Demolition of a silo & erection of an office building (B1(a) Business), 6 No. parking spaces for office workers & erection of boundary fencing.

Silo at Former McIntyre Nursery Littlehampton Road Ferring

Thank you for your internet representation made on 1st December 2019 which has been recorded as '**an objection**' with the comments as follows:

4 East
1 : 100

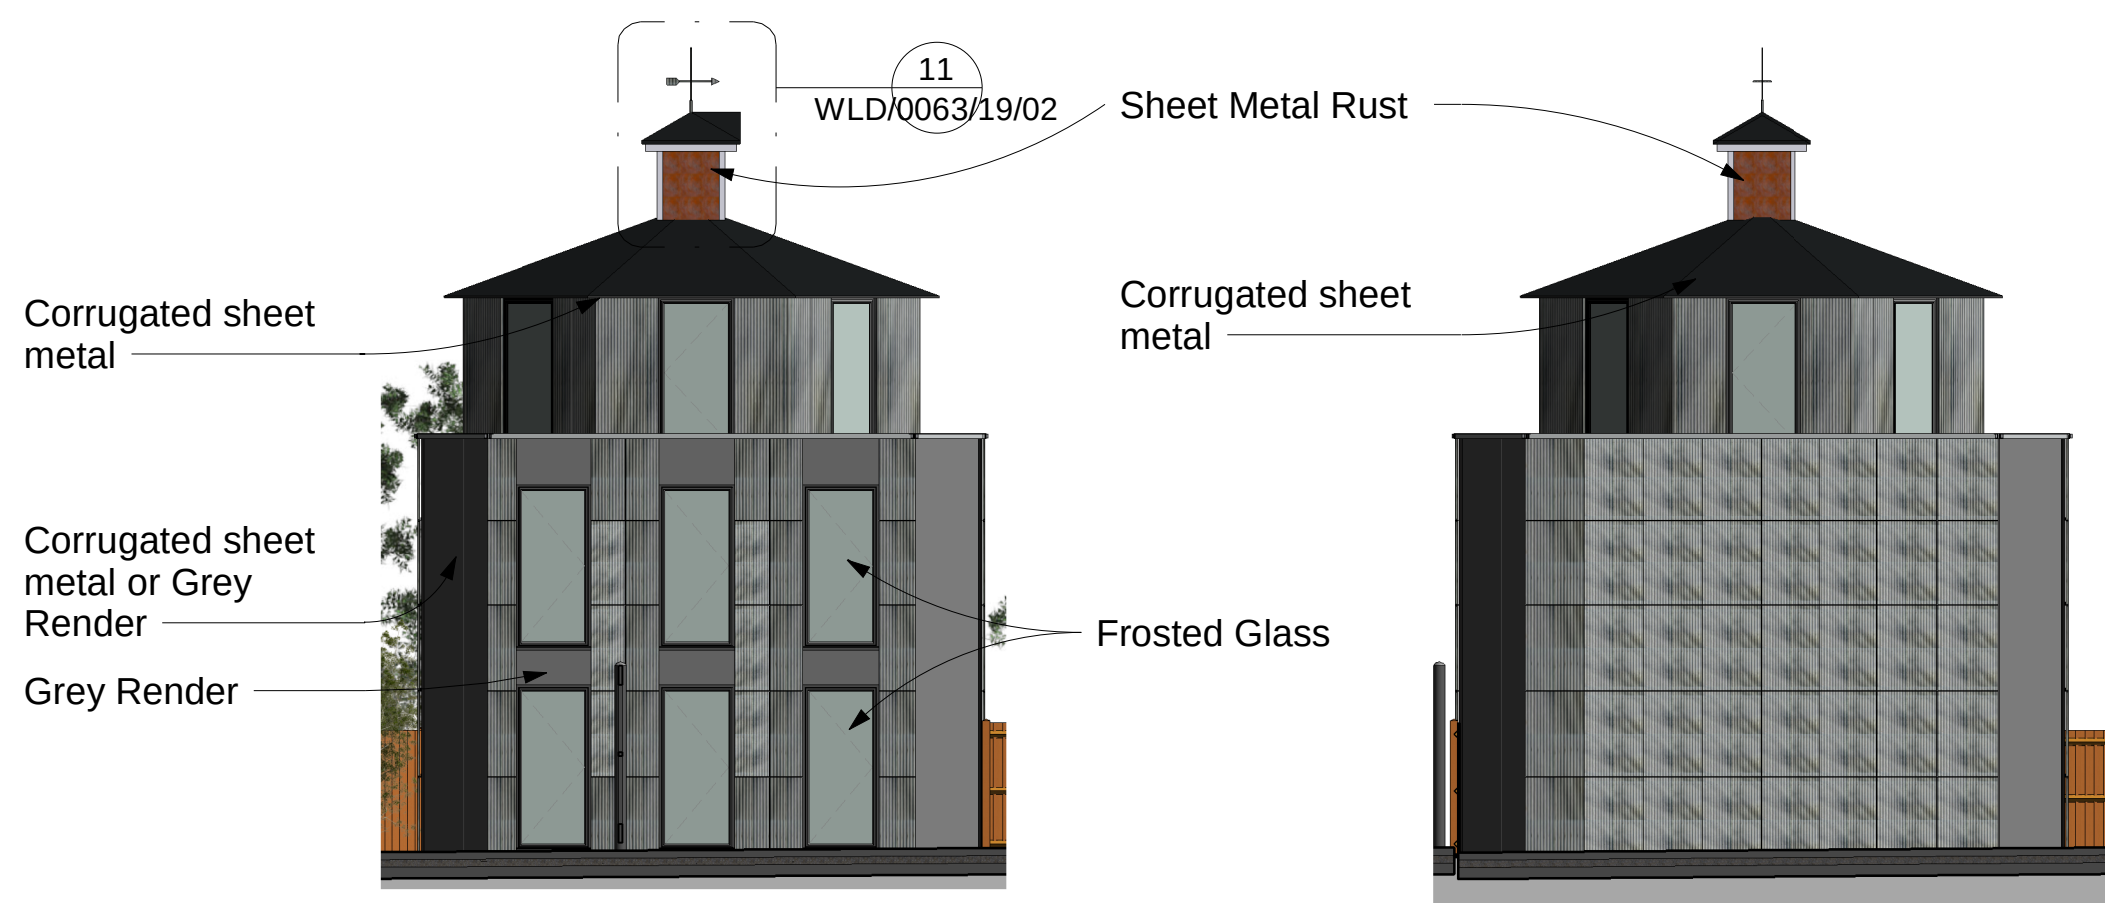
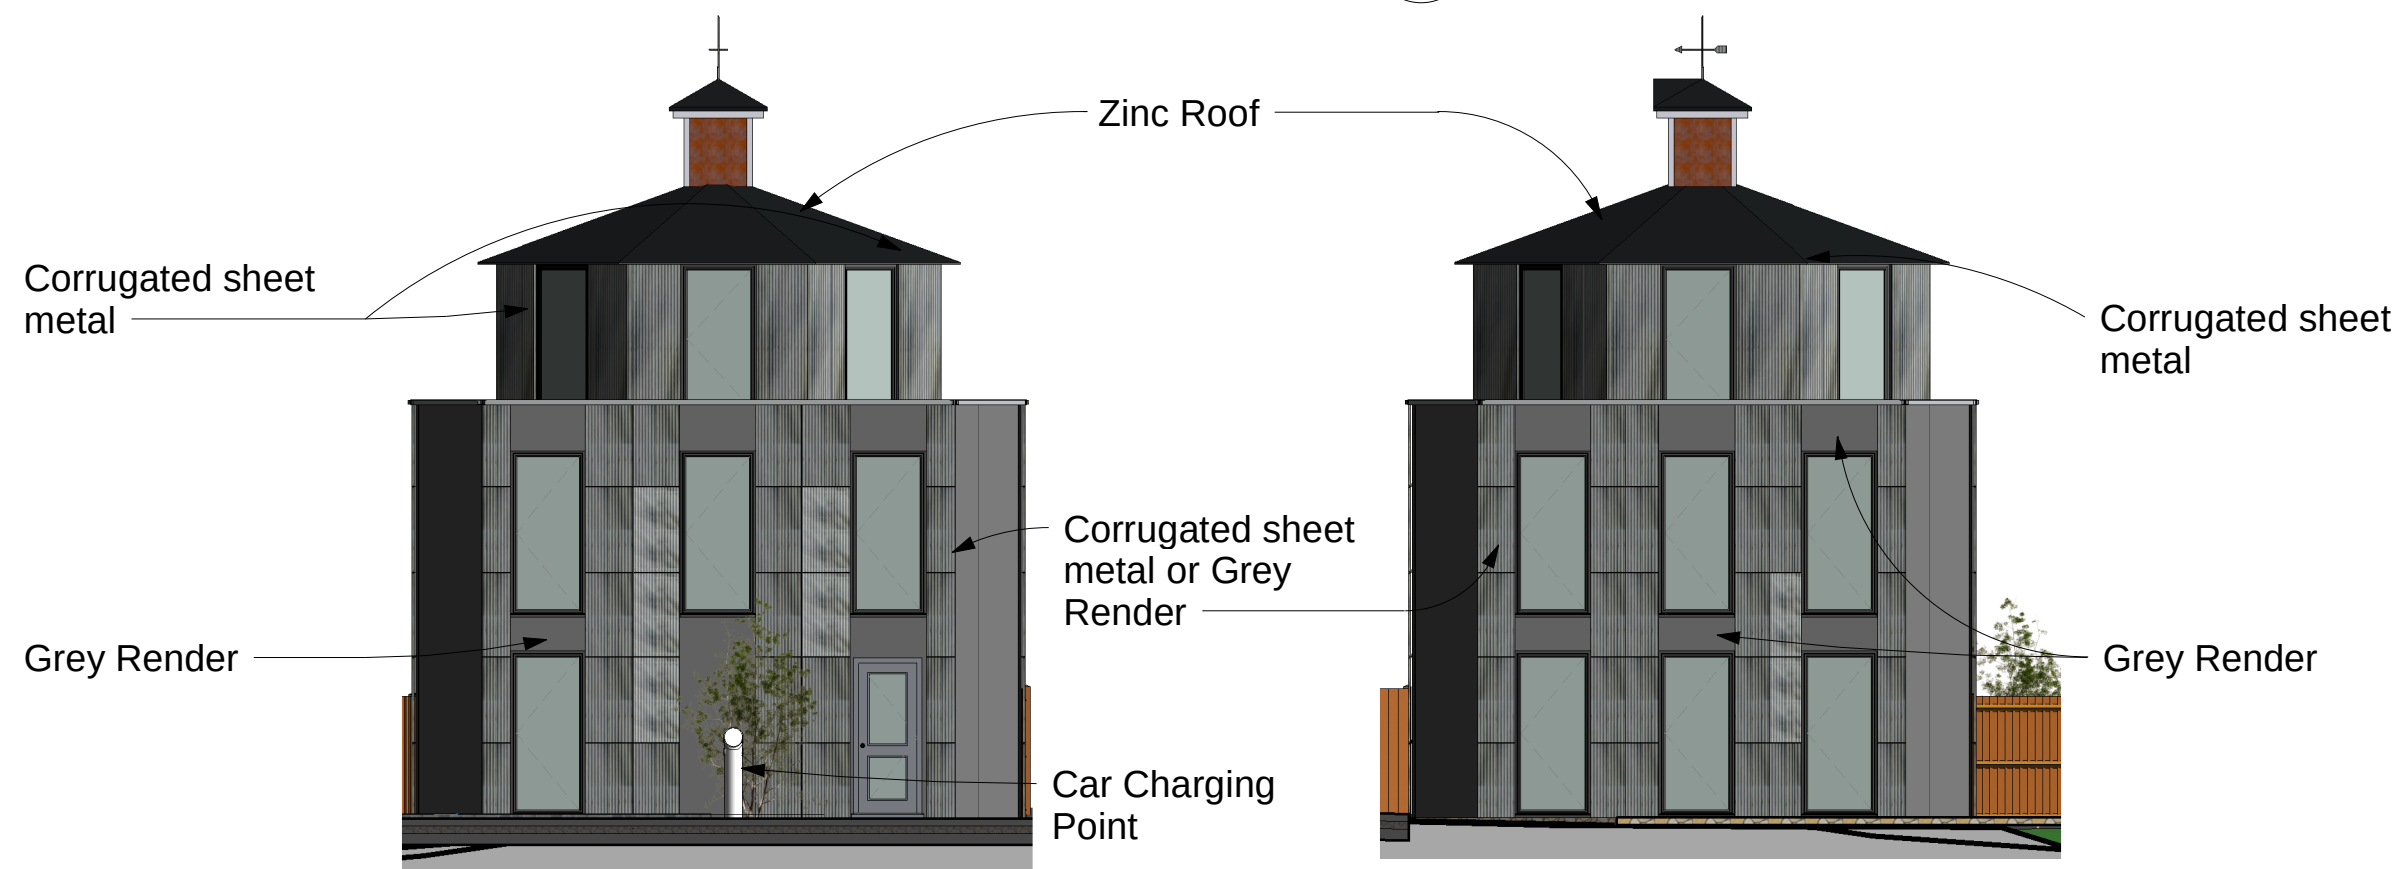
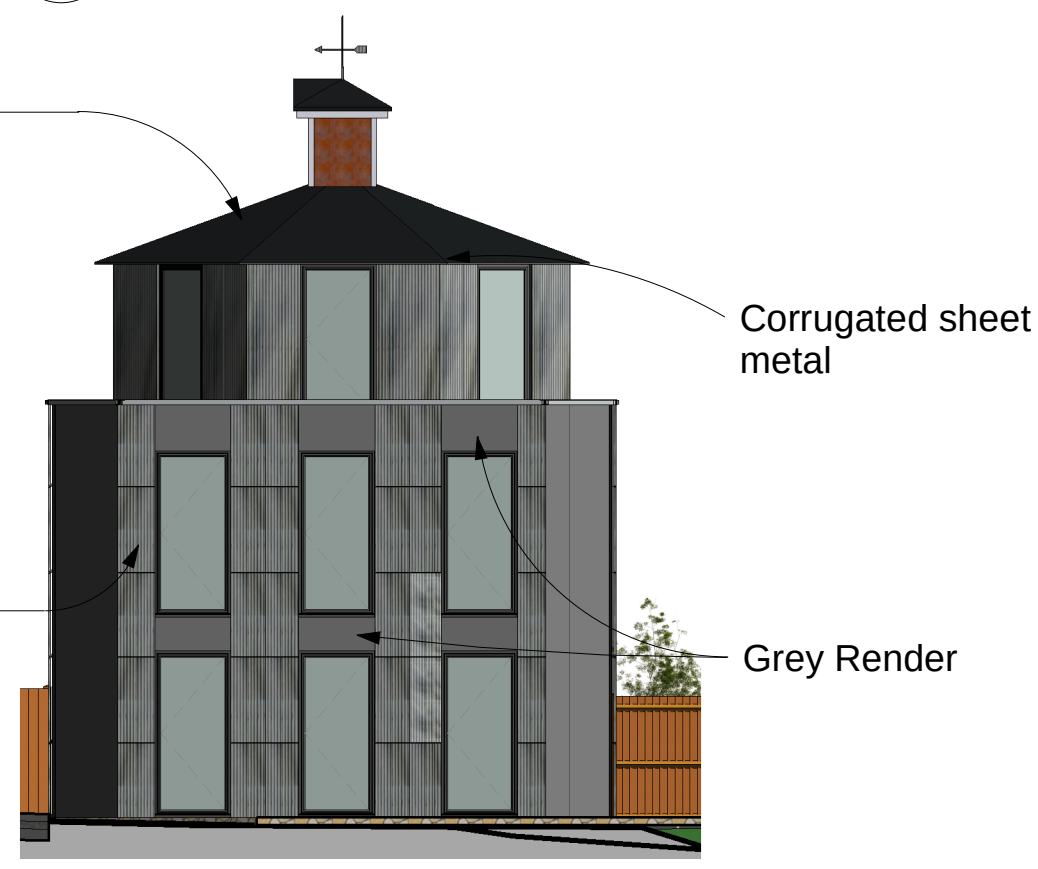
The previous application was for the conversion of an old grain silo, which is a much more acceptable proposal in such a rural location. The present applications is for a new building, with much larger office space, on three floors instead of two and with six places instead of four. It looks like an attempt to build on the previous consent, and is surely something that would have been refused had it been submitted in this form at that time.

The bulk and the design are gross intrusions into the local landscape, in the foreground of Highdown and the National Park. The additional traffic in the lane will create more conflict with pedestrians and horse riders in what is primarily a bridle path and footpath. It should be refused.
